From: Joanne Lewis <Joanne.Lewis@arun.gov.uk>
Sent: 07 October 2021 13:25
To: Planning.Responses <Planning.Responses@arun.gov.uk>
Subject: RE: Planning Consultation on: BR/218/21/PL

Application No: BR/218/21/PL

Description of Works: Provision of specialist paint booth in existing light industrial building including roof ducts/vents. This site is in CIL Zone 4 (Zero Rated) as other development.

Title
PROPOSED GROUND FLOOR PLAN

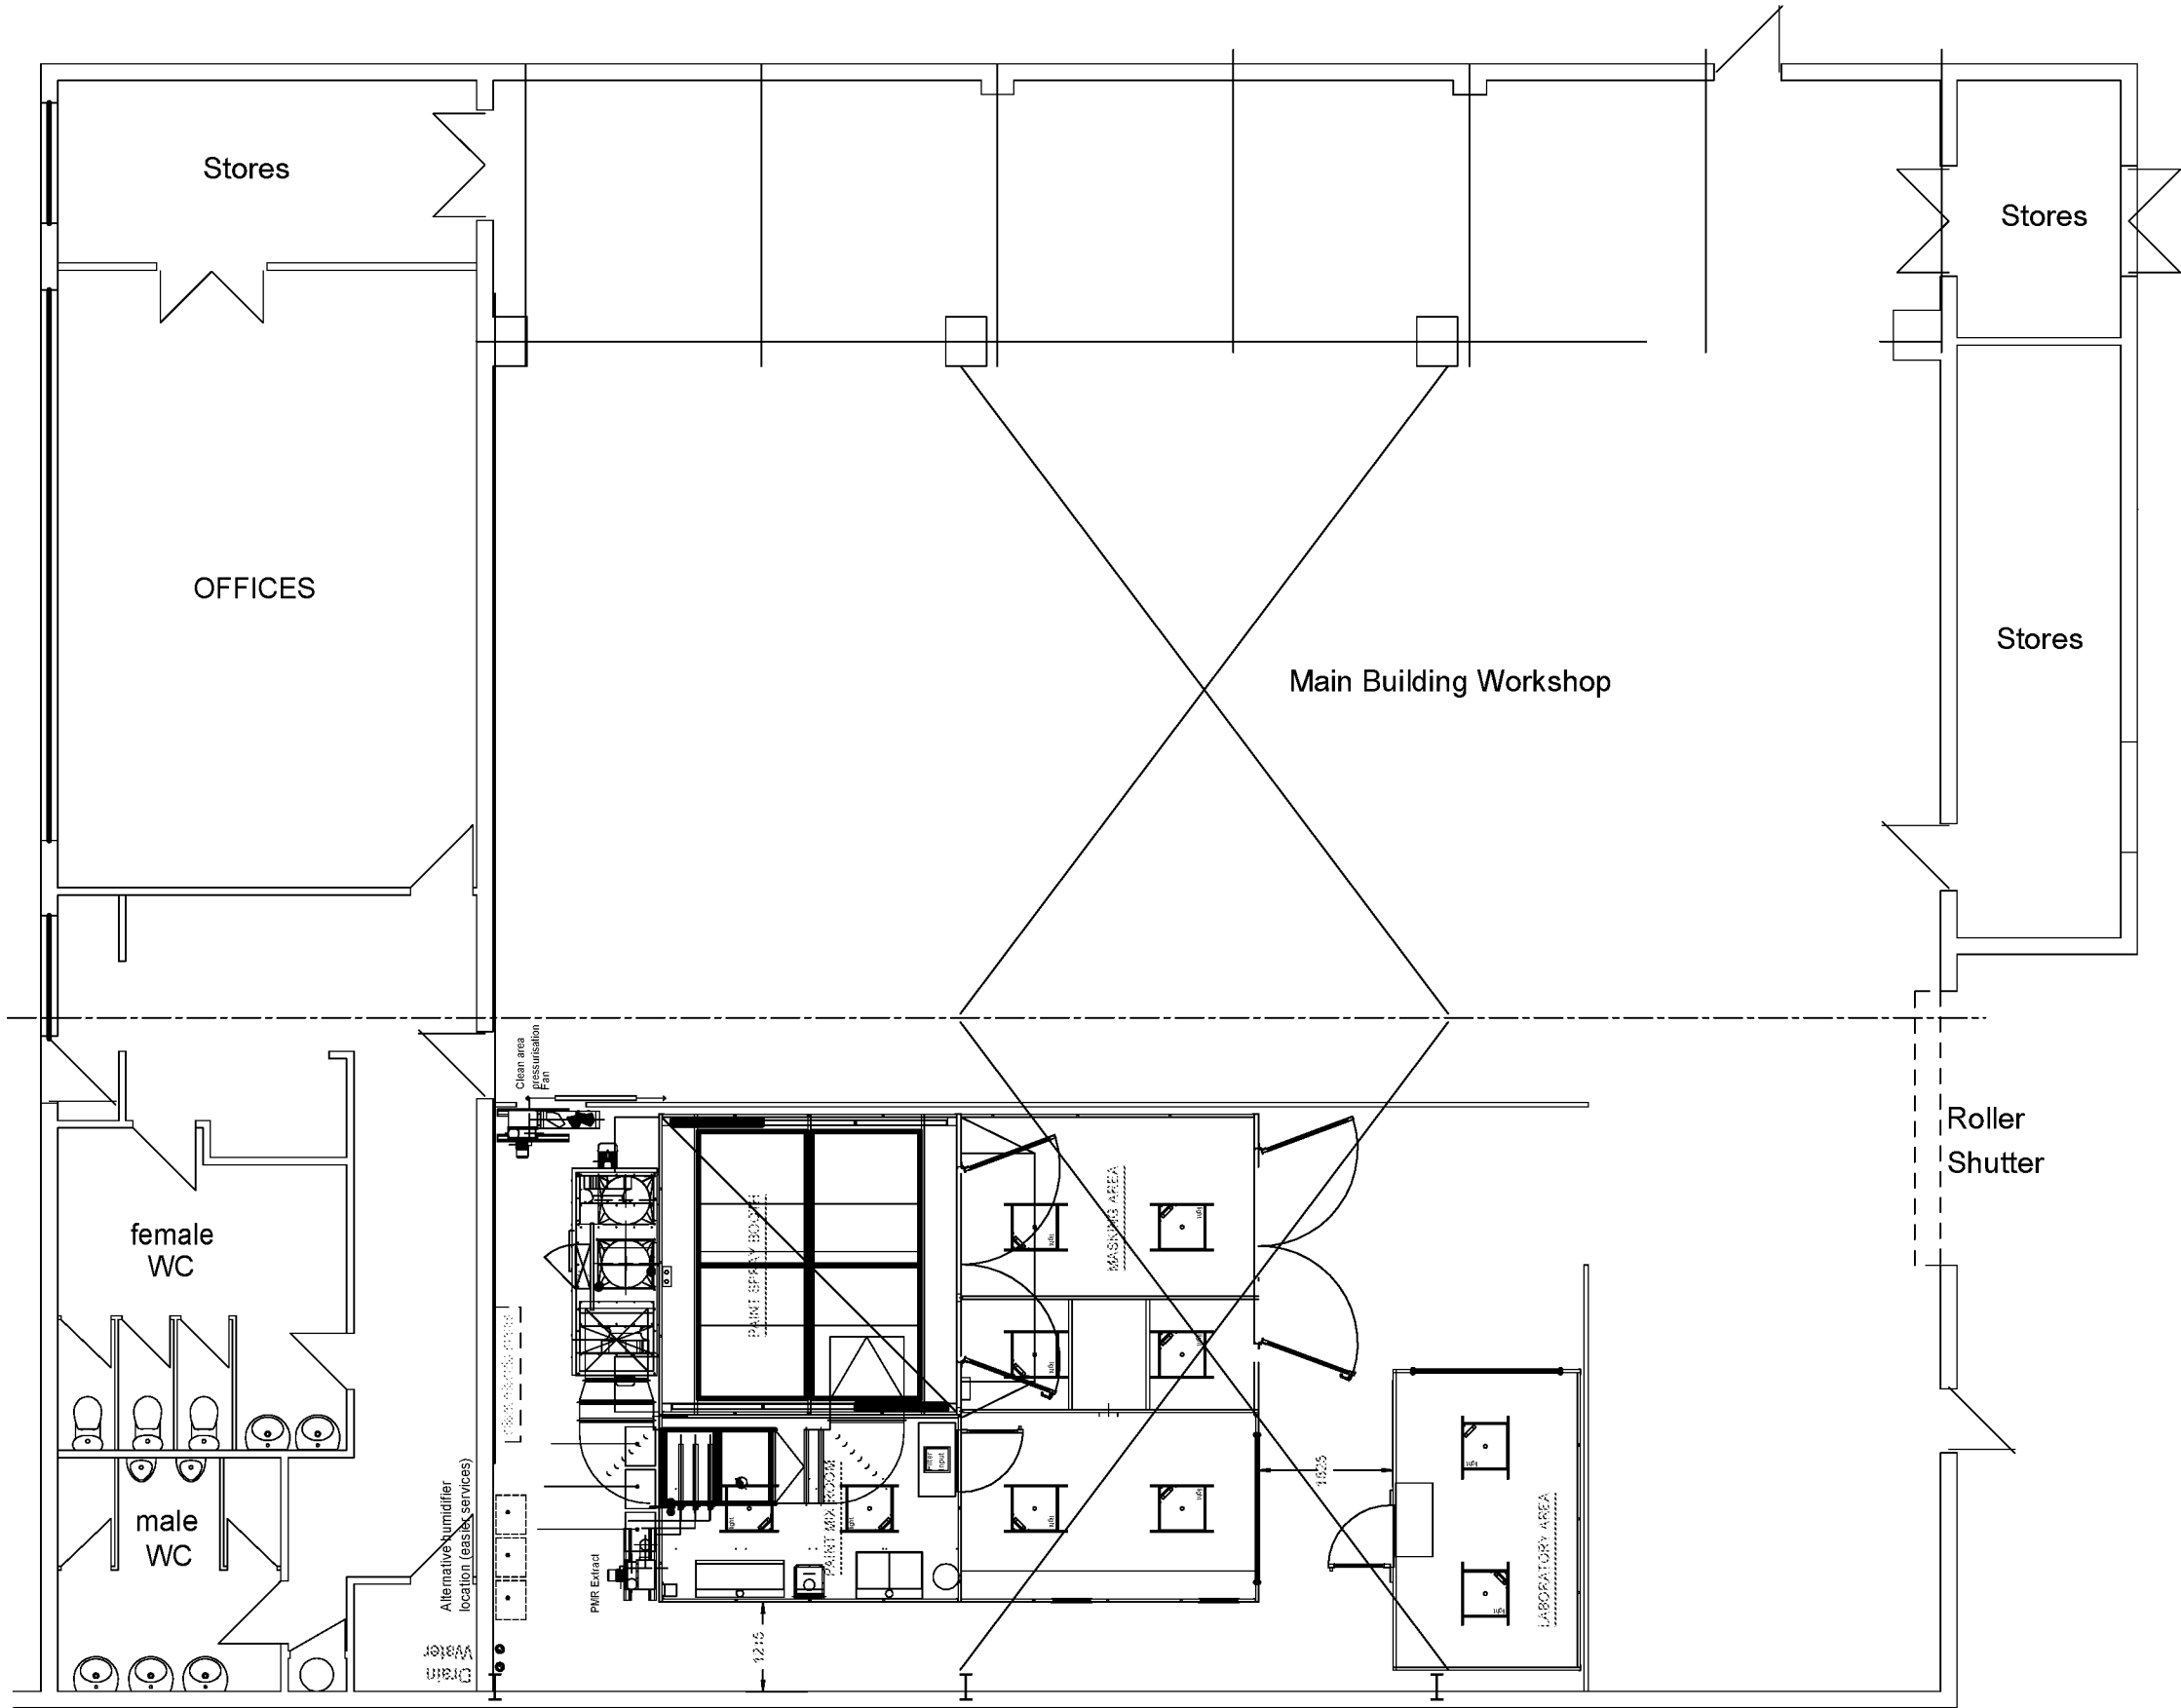
- The use of paint spray booths may require a permit under the Environmental Permitting Regulations 2016 depending on the type and quantity of paints or products to be used. If a permit is required this may dictate the stack heights in order to allow for adequate dispersion. In order to ensure that the stack heights applied for will be suitable should a permit be required, more information should be provided on the type and quantity of paints that are proposed to be used in the spray booth and what materials and products they are being applied to. The applicant may wish to review the process guidance note relevant to their business for further information on permit requirements (most likely under the solvents section) and the relevant note should be referred to in the extra information submitted. [Local Air Pollution Prevention and Control \(LAPPC\): process guidance notes - GOV.UK \(www.gov.uk\)](#)
